TIERRA WEST, LLC

January 25, 2024

**RE: 2023018 SAGE PLAZA STORAGE
EROSION AND SEDIMENT CONTROL PLAN**

Per the correspondence dated January 9, 2024, please find the following responses addressing the comments listed below:

\\TINASZ\_Drive\2023\2023018 Storage Units Lot 1B Snow Vista Investors\dwg\EPC\2023018\_SWPPP.dwg Jan 04, 2024 -- 3:00pm

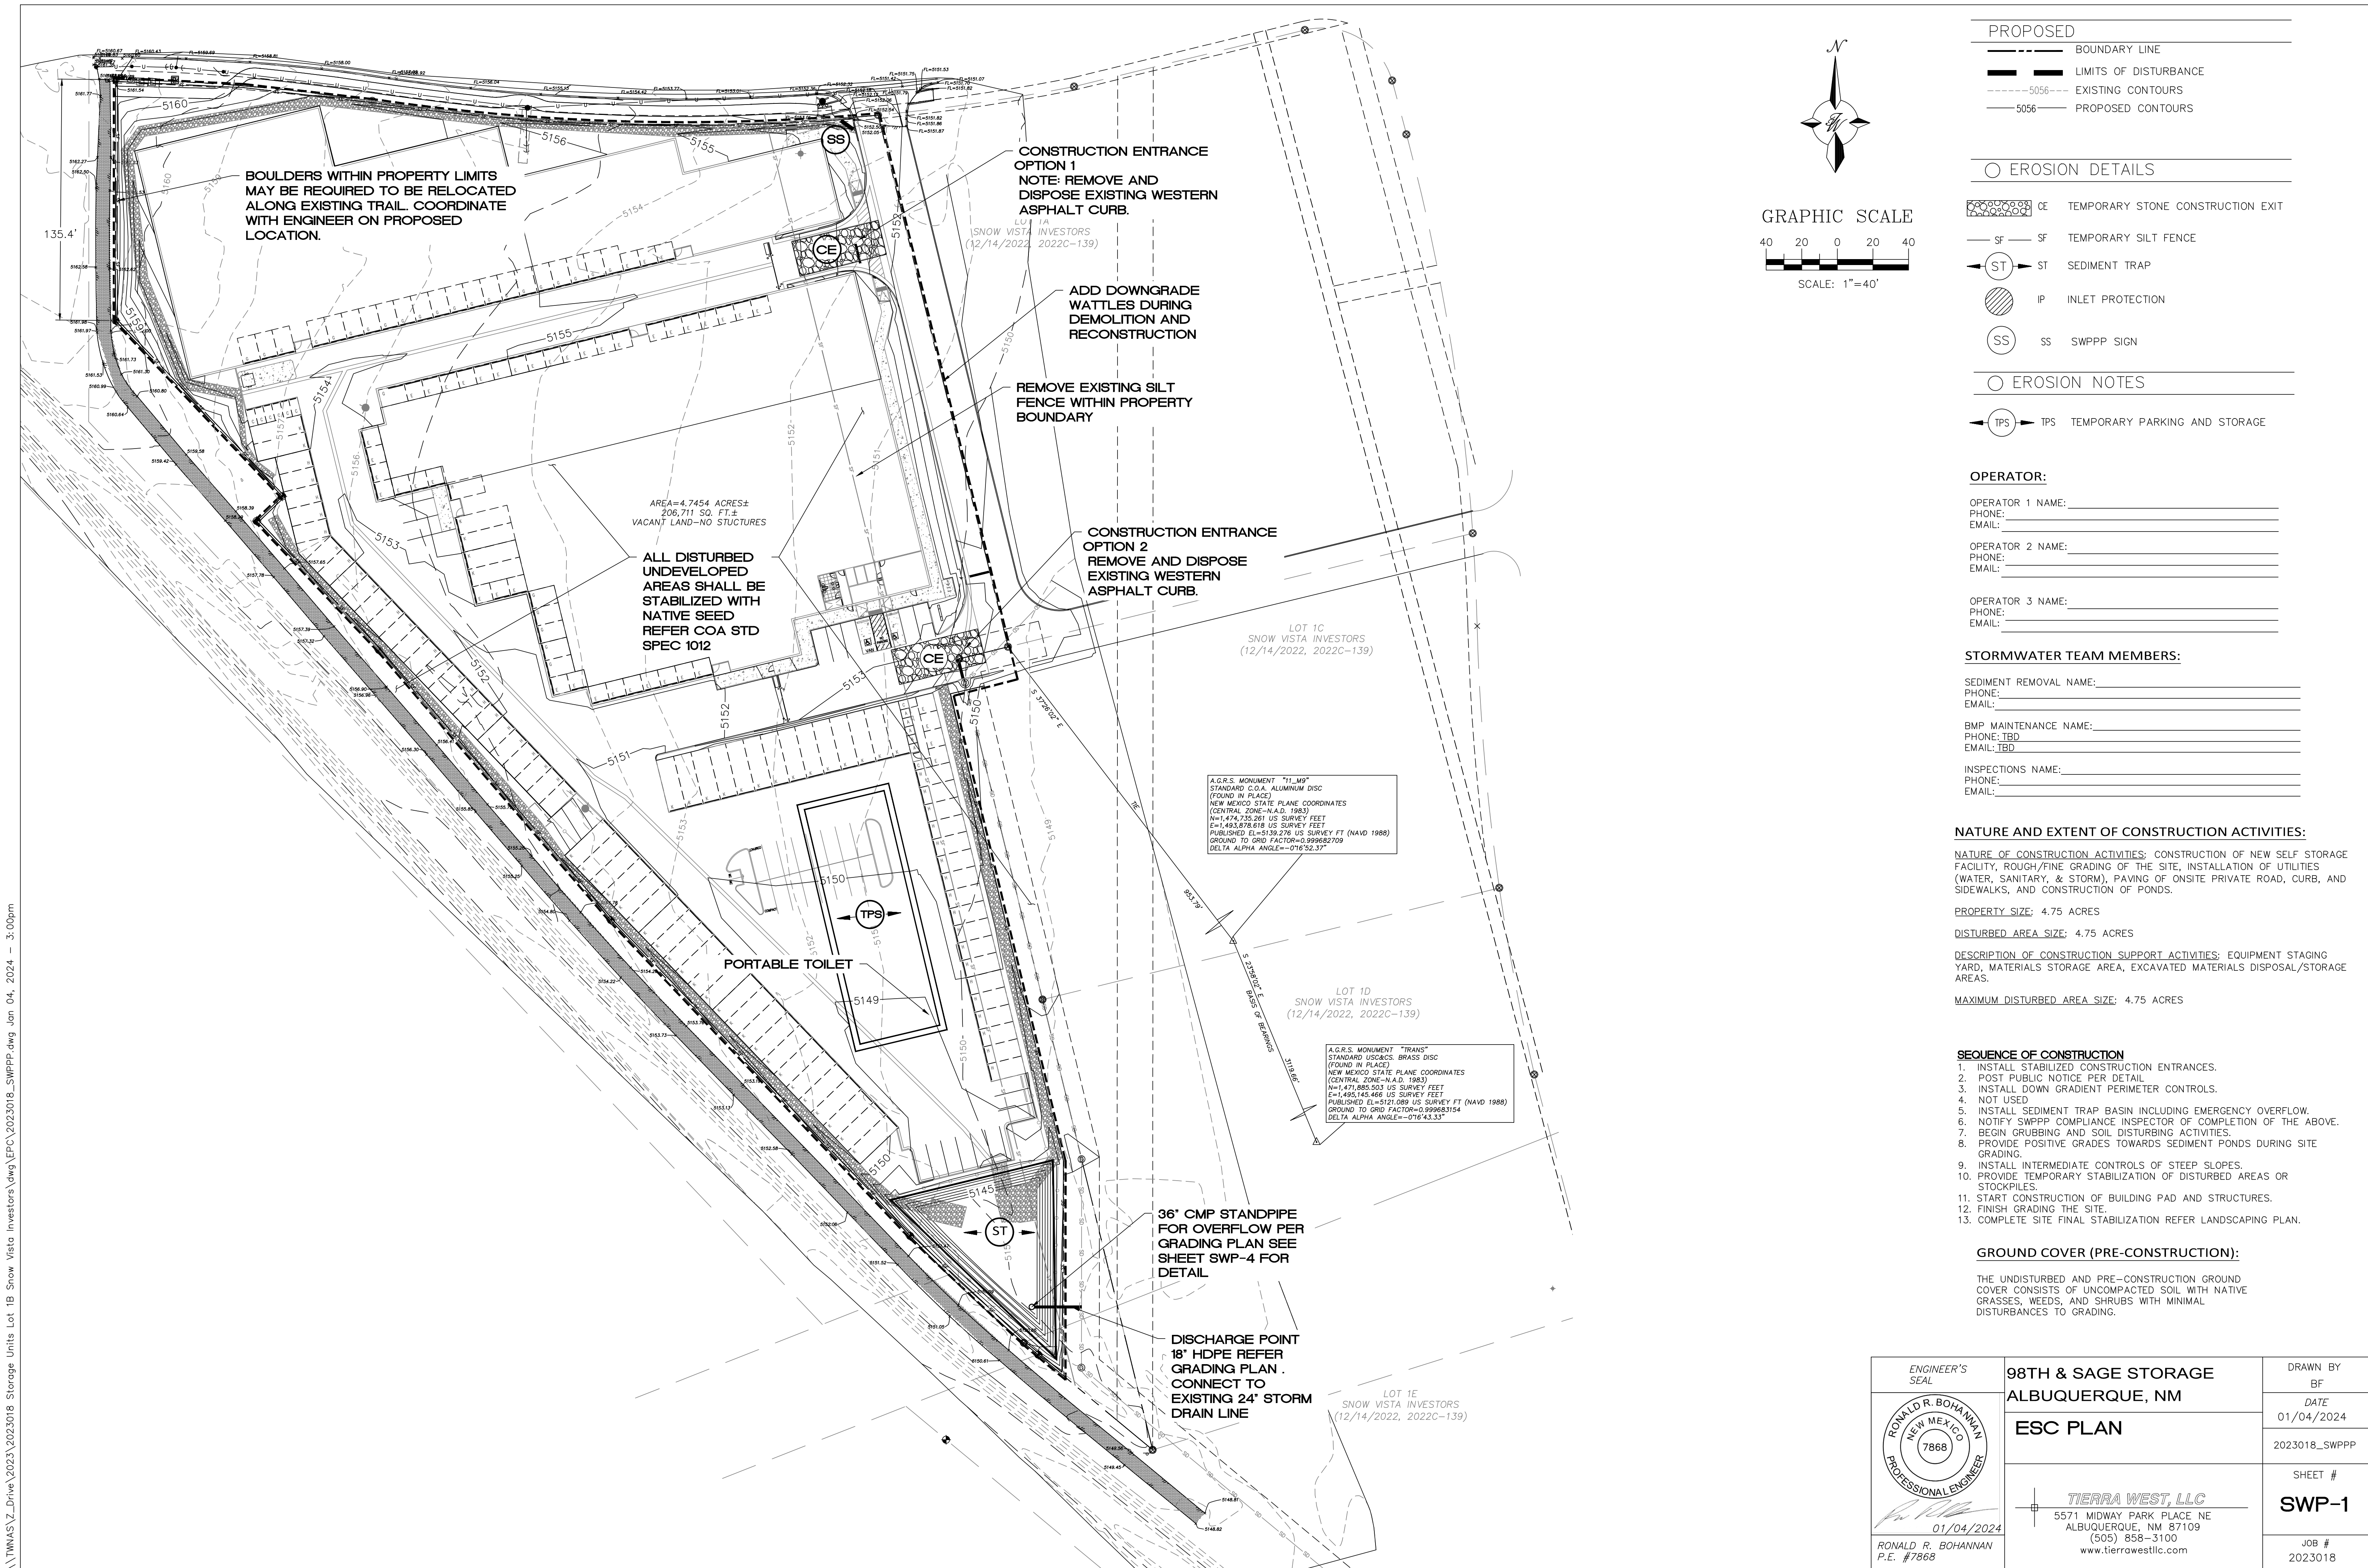
Response: Hydrology has approved the grading plan on January 18th, 2024.
4. The SWPPP must include site-specific interim and permanent stabilization per CGP 9.6.1.c.i. Provide a specification on the ESC Plan along with schedules for implementation per CGP 2.2.14. Label areas where existing vegetation is to be preserved and not graded at this time. Label areas to be stabilized with landscape rock (all areas in the public ROW) and show typical section and specifications. Label areas to be stabilized with vegetation and provide details and specifications.

Response: Earth disturbance will be limited within the bounds of construction. Exposed earth surfaces will be landscaped per the landscapers plans else the site shall be stabilized with native seed as noted on sheet SWP-1.
